Application No: P/116/19/OUT
Site Address: Land adjacent to Sefter School House Sefter Road Bognor Regis PO21 3EE
Description of works: Outline application with all matters reserved, except for access, for the erection of 4 No. semi-detached 3-bedroom houses & 2 No. detached 4-bedroom houses with associated access, parking & gardens. This application is a Departure from the Development Plan.

Thank you for your internet representation made on 2nd June 2020 which has been recorded as an objection with the comments as follows:

OWPC27399

Proposed Site Access Arrangements

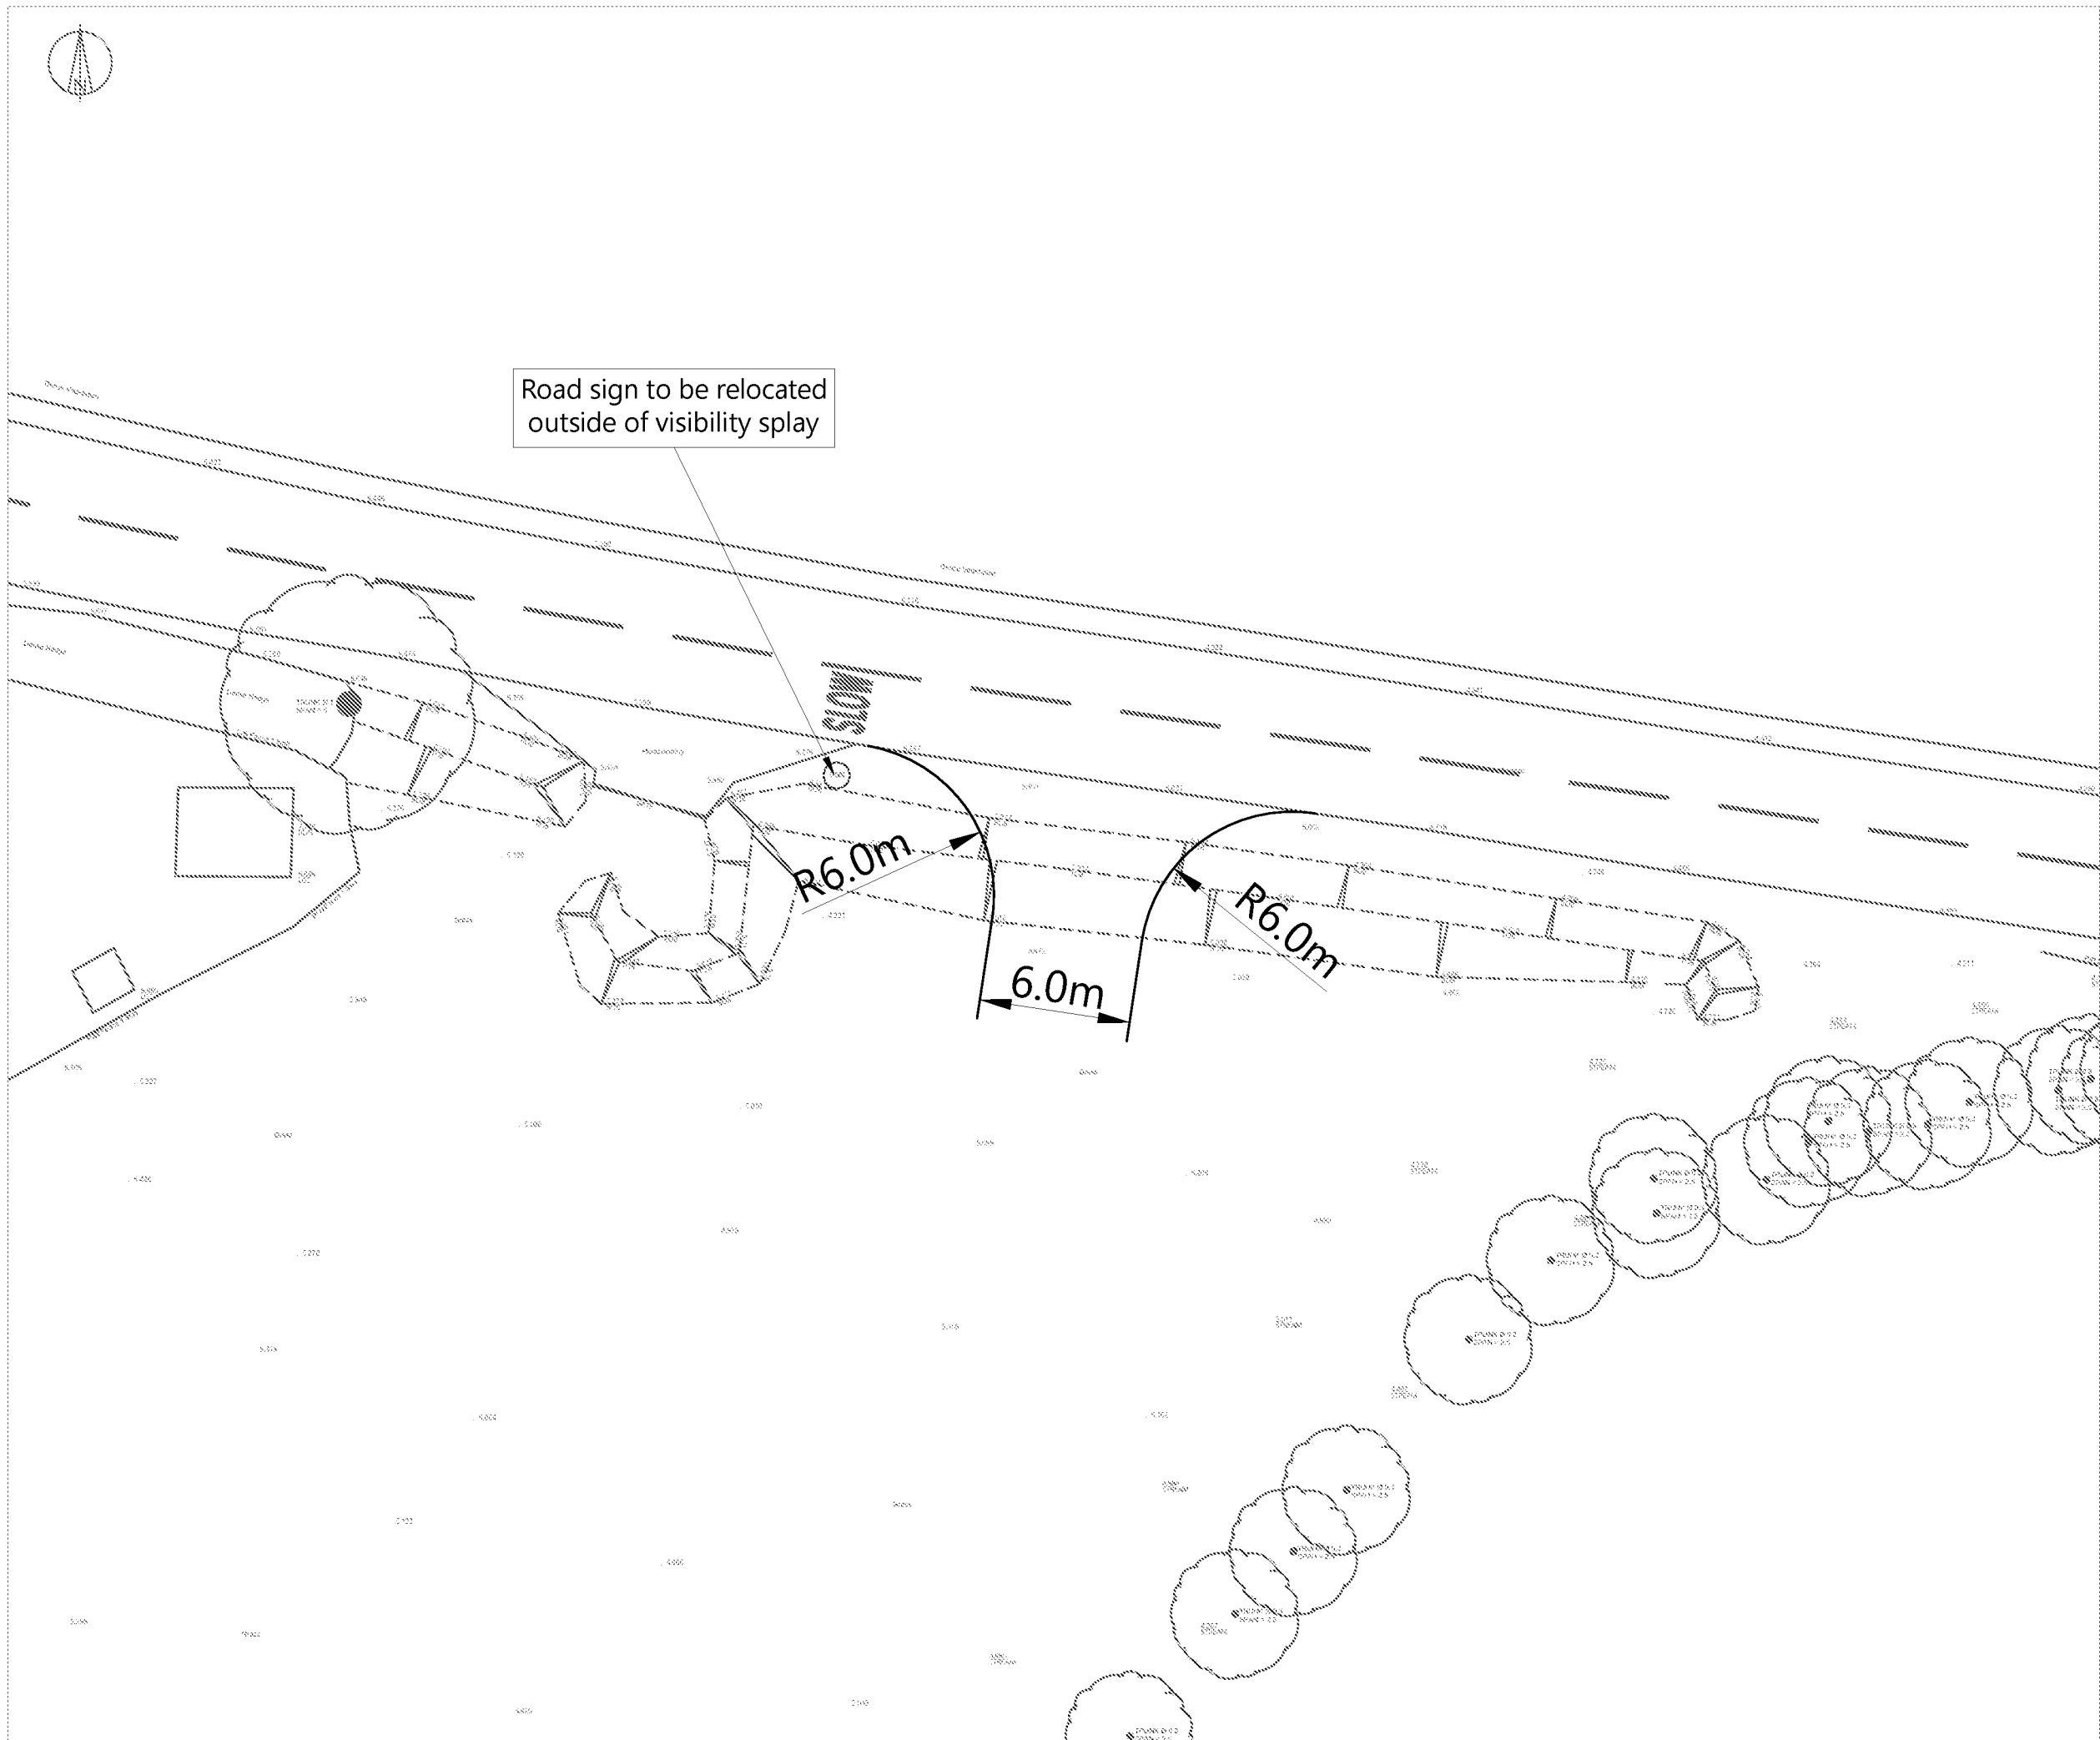
There is also an issue with the exit and entrance traffic arrangements as presented due to the proximity of the Sefter Rd./Pagham Rd. junction which has contrary to information stated suffered many accidents due to its poor visibility splay to the left towards Pagham, the 60 mph speed limit and the skewed angular exit positioning when exiting this junction towards Chichester limiting visibility due to a blind bend and a dip in the road looking left. WSCC has used a desktop study and failed in its duty as the LHA to take this into consideration. It is quite common for traffic to queue back past this developments entrance/exit as well because of a rat run effect caused by traffic taking an alternative route to Chichester on the Lower Bognor

WSCC have tried to argue that S106 monies will allow this junction to be upgraded (Ian Gledhill produced an LHA study on this) yet ADC have separately commissioned a desktop study which completely contradicts the LHA report thus undermining a clear way forward to address the issues that exist at that junction. All the above points need clarification and a definitive safe solution with respect to both areas of objection.
